OXFORDSHIRE COUNTY COUNCIL'S RESPONSE TO CONSULTATION ON THE FOLLOWING DEVELOPMENT PROPOSAL

Application no: 23/00977/OUT

Proposal: Outline Planning Application (except for access) for residential development of up to 60 dwellings (Use Class C3) including a community facility, new vehicular and pedestrian access off Claydon Road, public open space and associated landscaping, earthworks, parking, engineering works and infrastructure

Location: OS Parcel 9195 North Of, Claydon Road, Cropredy

Title :
Proposed Site Access & Visibility Splays

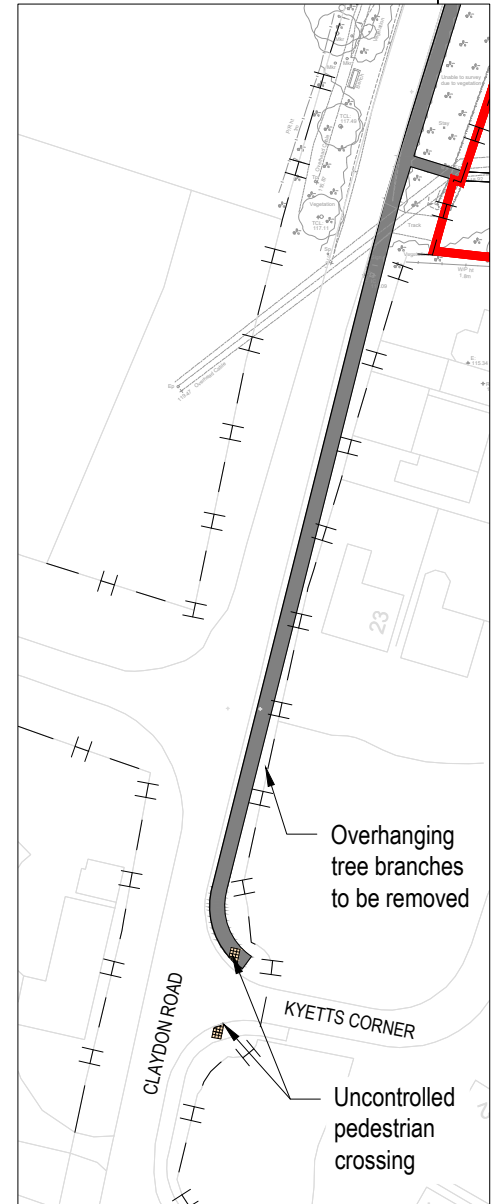
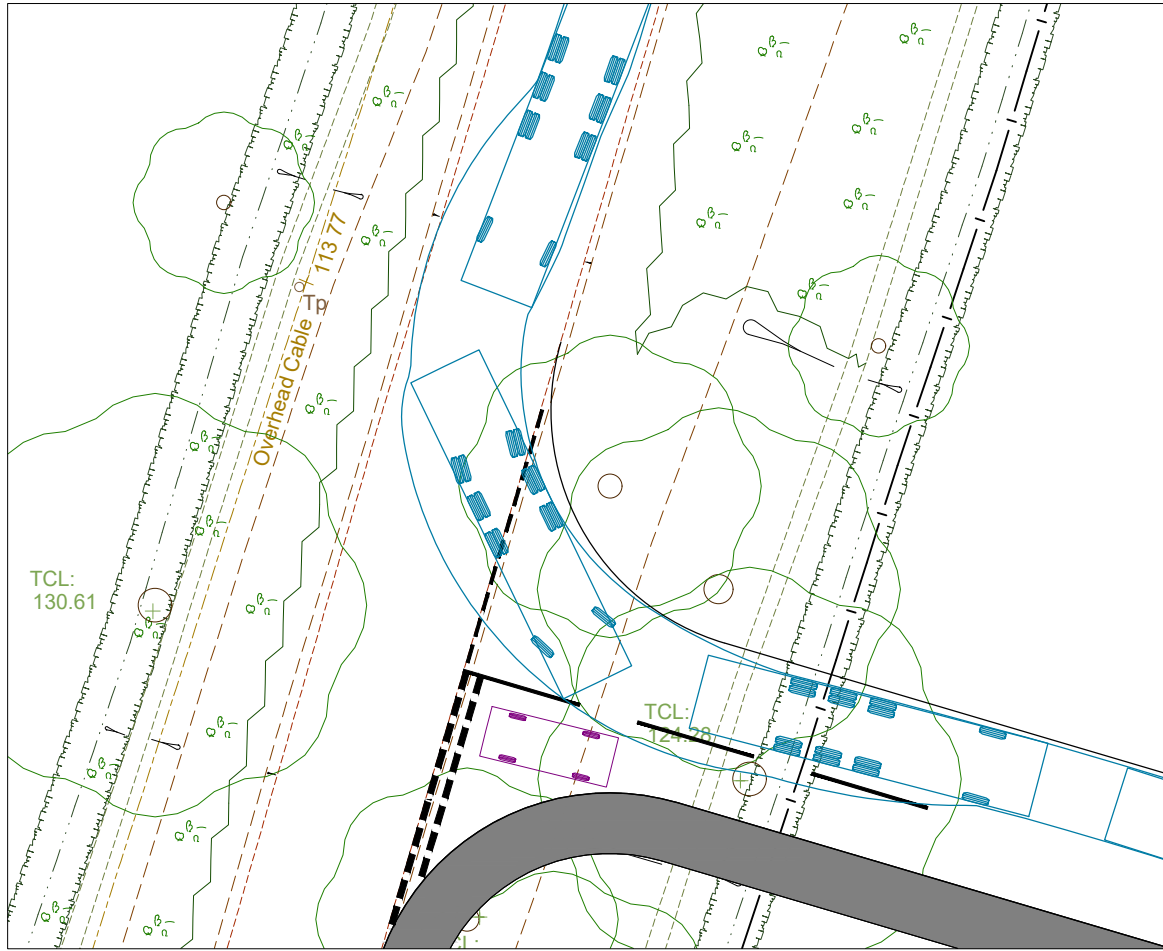
- Amendments needed to access arrangements drawing
- Clarification required on proposed bridge over canal

However, in our response of August 2023 we requested amendments and clarification to the access arrangements drawing, and clarification regarding the proposed bridge over the canal. This does not appear to have been addressed.
